PLANNING CONSULTATION RESPONSE

Application No	<u>2026/0671</u>
Proposal	Creation of driveway and parking area, new retaining walls, steps, alterations to ground level and conversion of integrated garage to habitable area at front of dwelling.
Address	30 Quarry Bank Close, Cudworth, Barnsley, S72 8BJ
Date of Consultation Reply	07/09/26
Consultee	Highways Development Control

PROPOSED
SIDE (LOWER PARKING) ELEVATION
SCALE 1:100

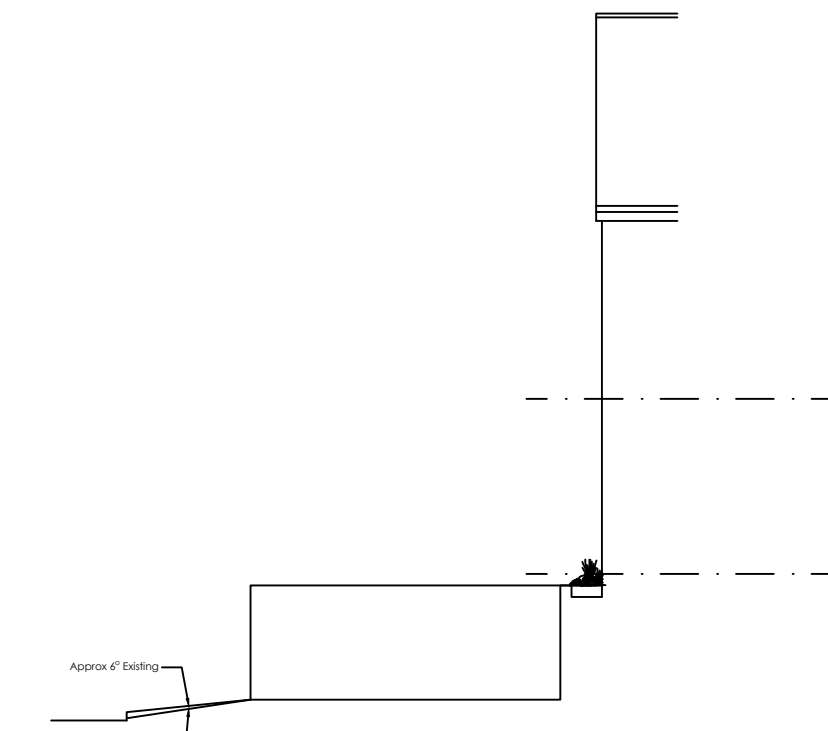
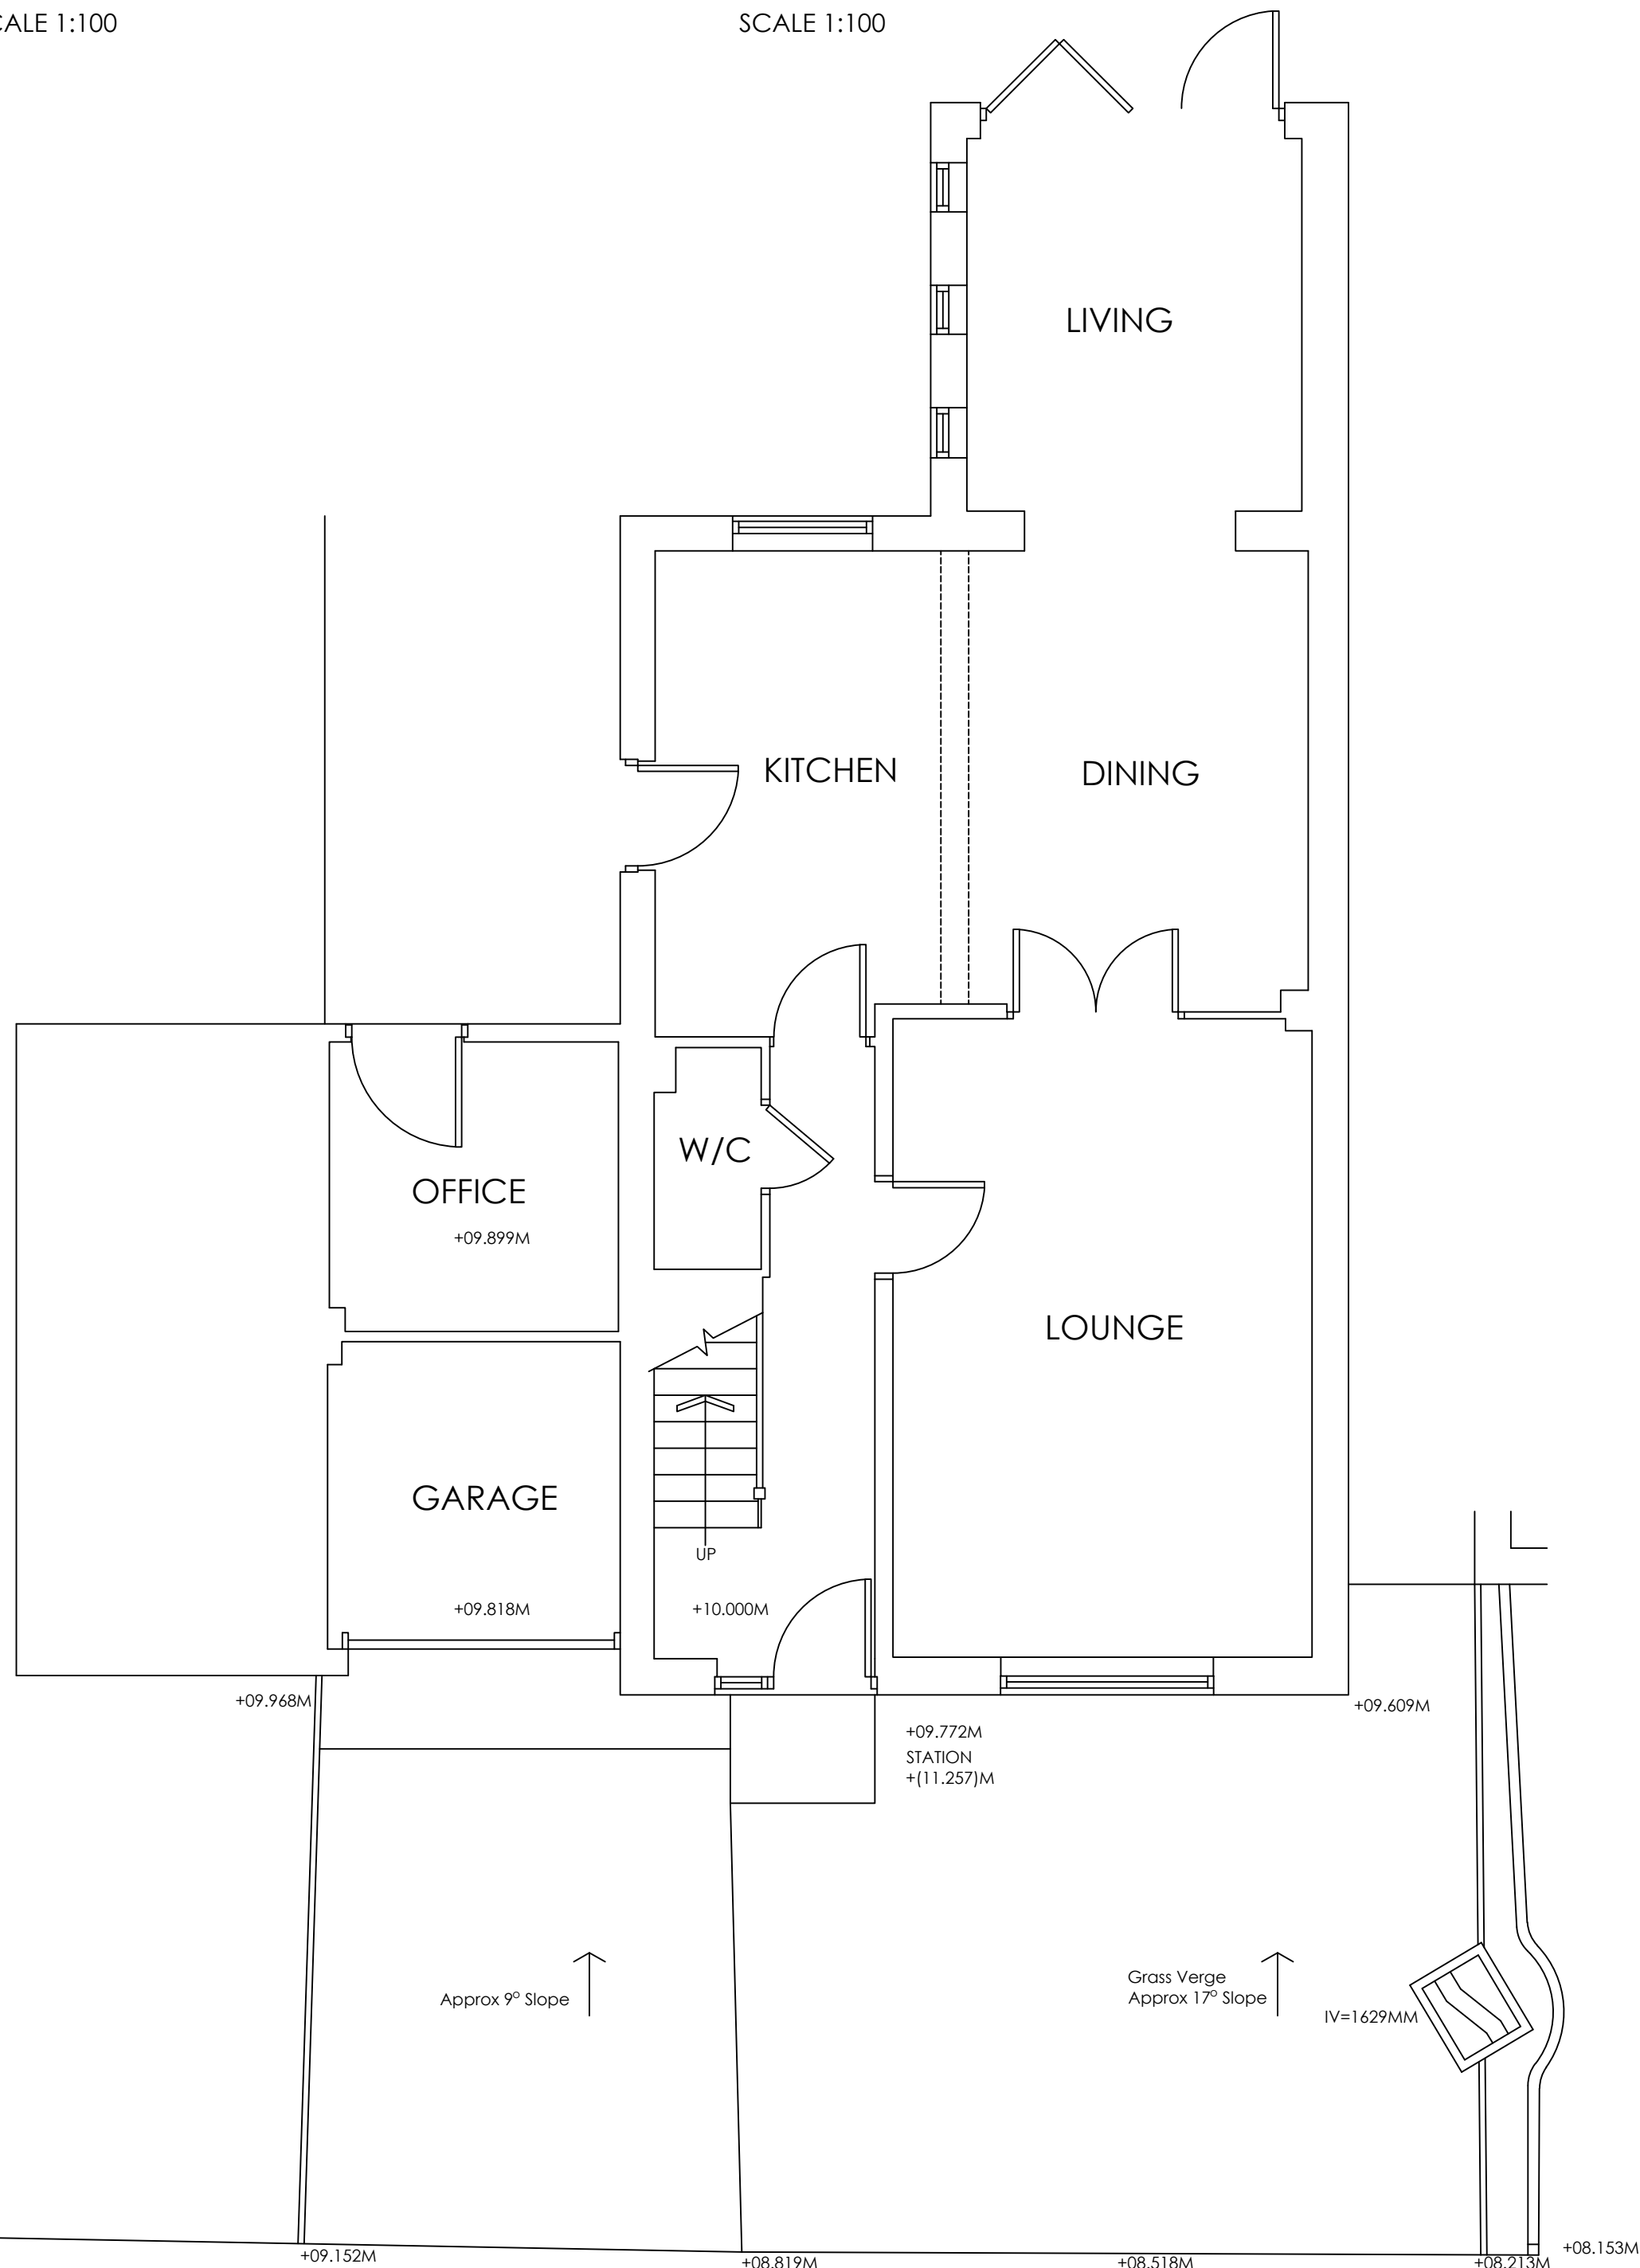
Whilst I have no objection in principle to the proposal, I note that the parking area appears to be less than 5 m in length, which is the minimum acceptable dimension for a parking space. I further note that the gradient is shown as 1:10, whereas the minimum acceptable gradient is 1:12.

I acknowledge that there are properties on the street with vehicular accesses that appear to exceed the preferred maximum gradient of 1:12. However, as the applicant is seeking to create a new access and off-street parking provision, the current standards and desired minimum requirements should be applied.
